Planning Officer: Neil Crowther
Planning Application Ref: A/23/15/OUT
Location: Land south of New Road & East of Brook Lane, Angmering
Description of works: Hybrid Planning Application

Consultant Arboriculturist

Drawing Number C117420-02-01 Revision 00

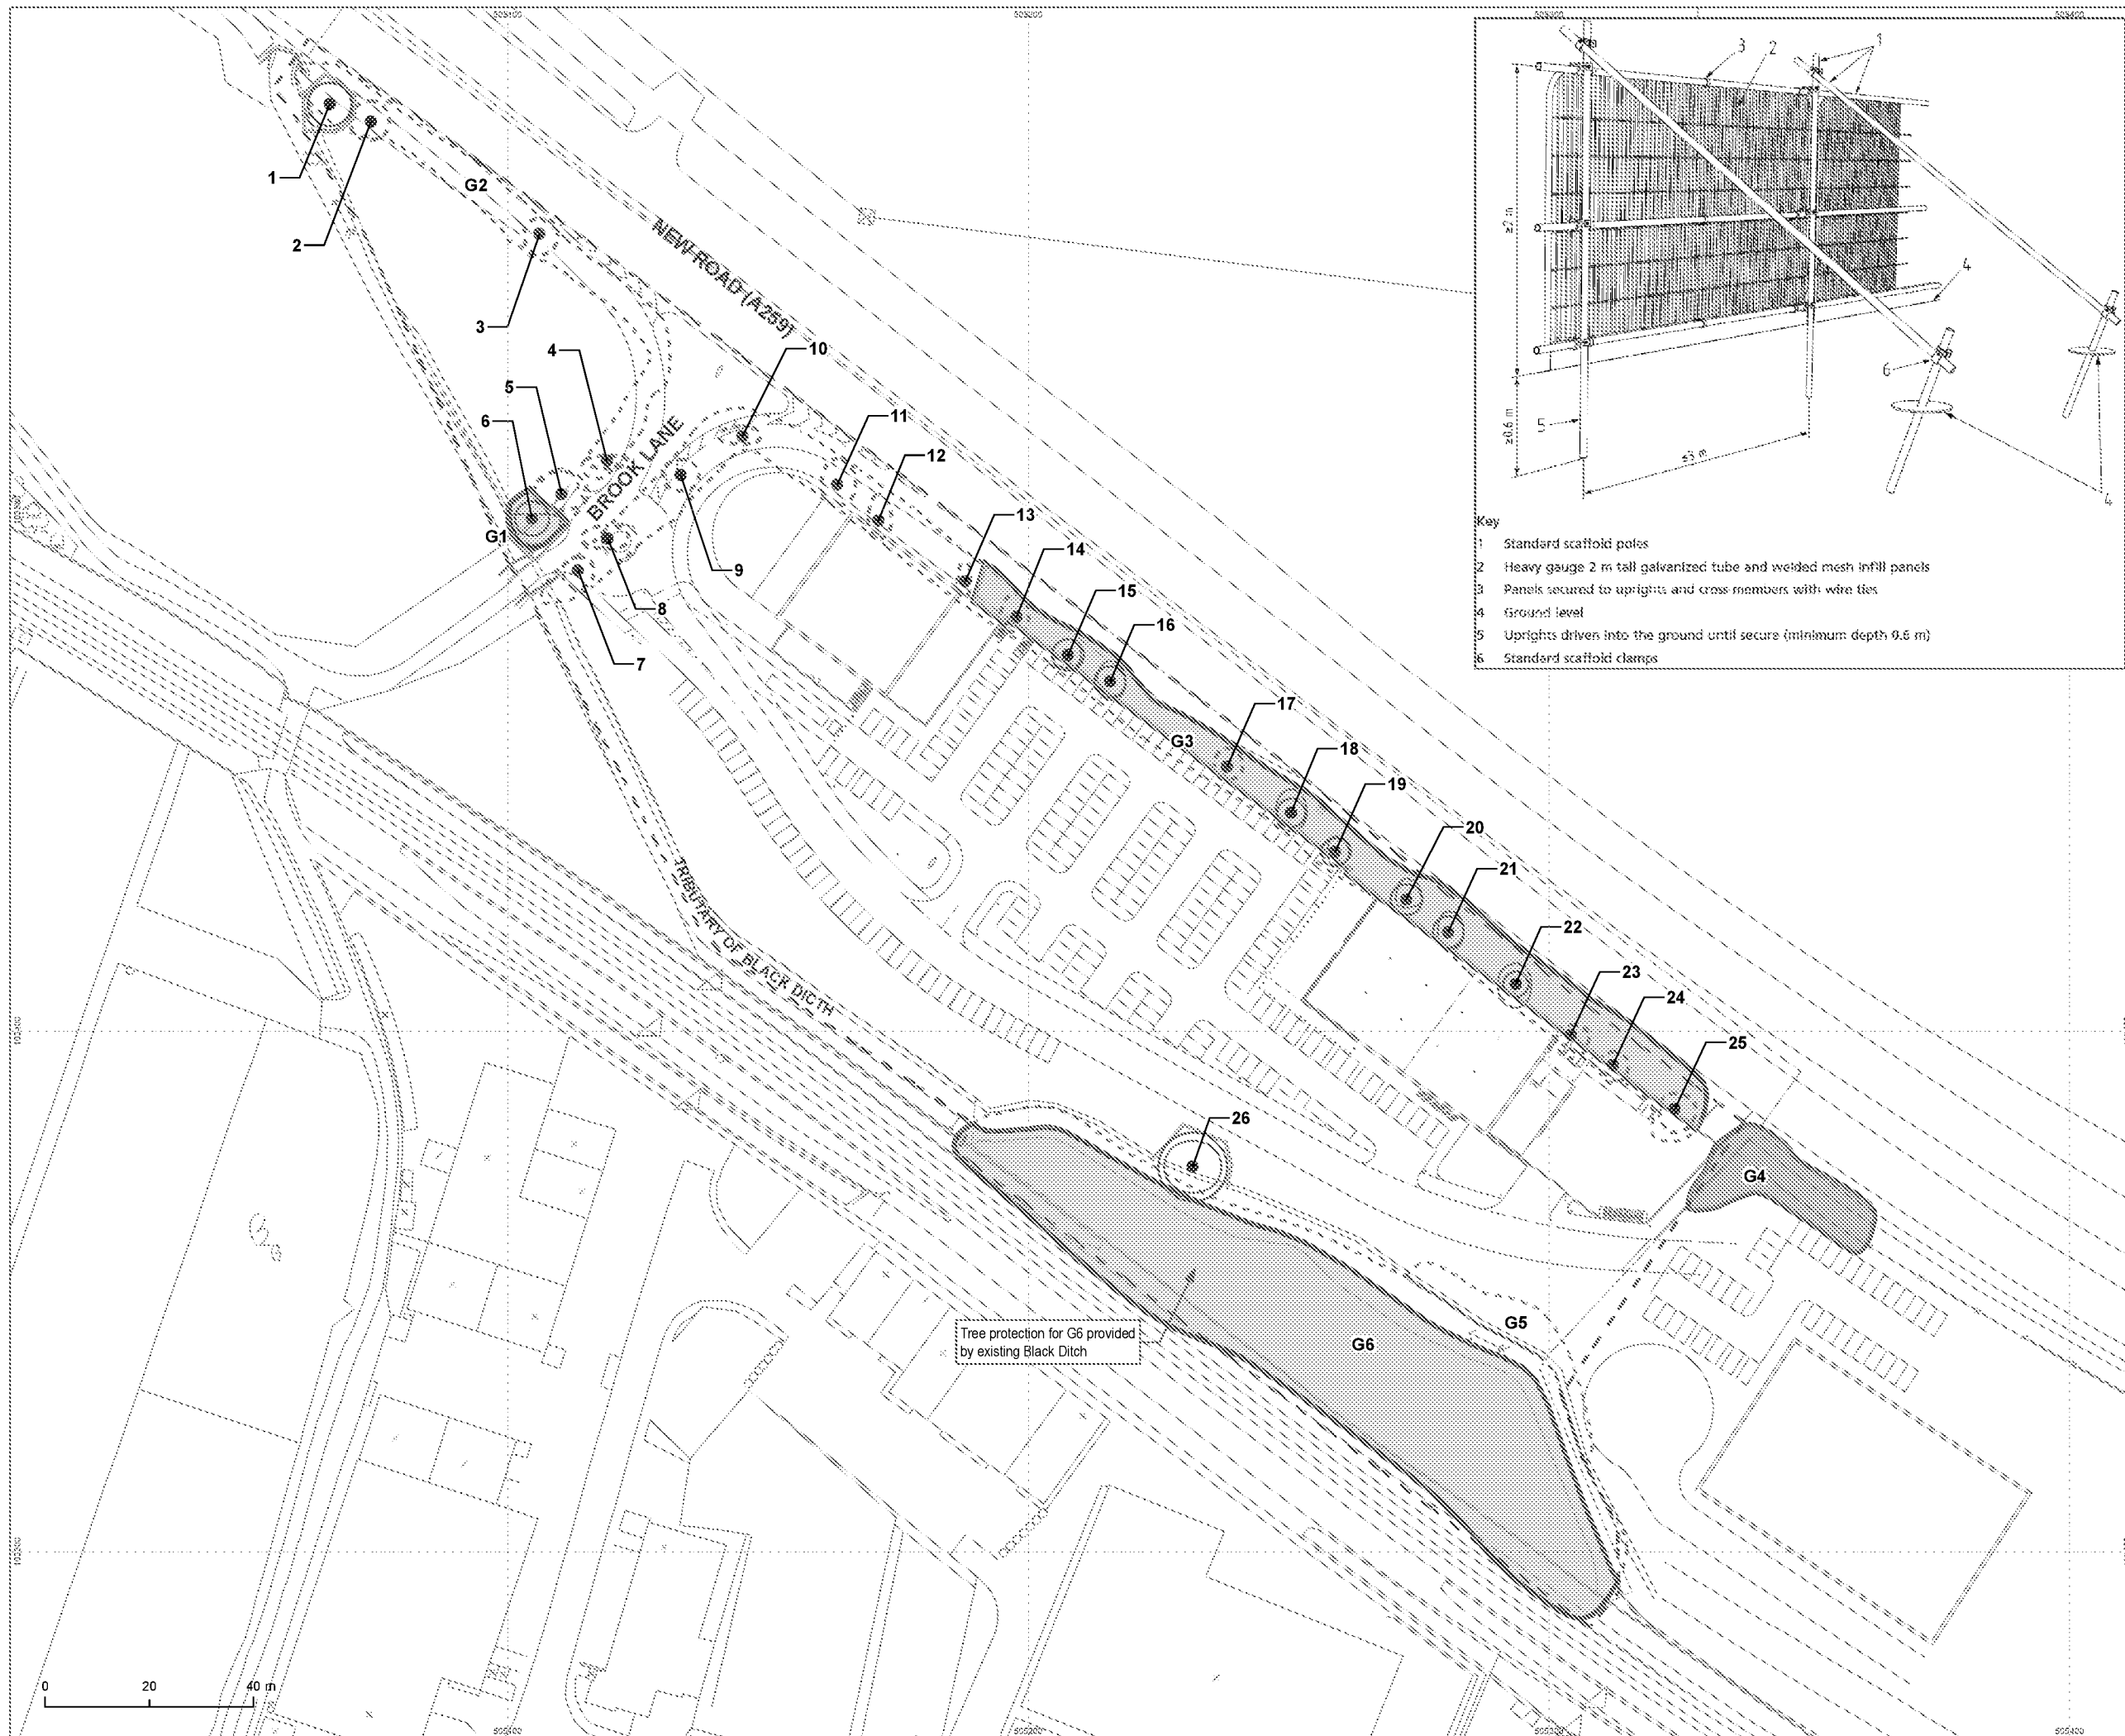
- I am not quite sure what I am being asked to comment on here as the site has an extant planning approval?
- I have reviewed the tree content and there is nothing of any real merit within the site.
- I have also read Dafydd Lloyds report of 4th April 2015 and this seems to adequately sum up the situation as far as trees and the proposals are concerned.

- They should be developing as shown on the layout plans approved and in strict accordance with the tree protection measures specifically detailed in **Middlemarch Environmentals - AMS Report [RT-MME-117420-03-Rev A] & Tree Protection Plan [C117420-03-01 Rev A –January 2015]**.
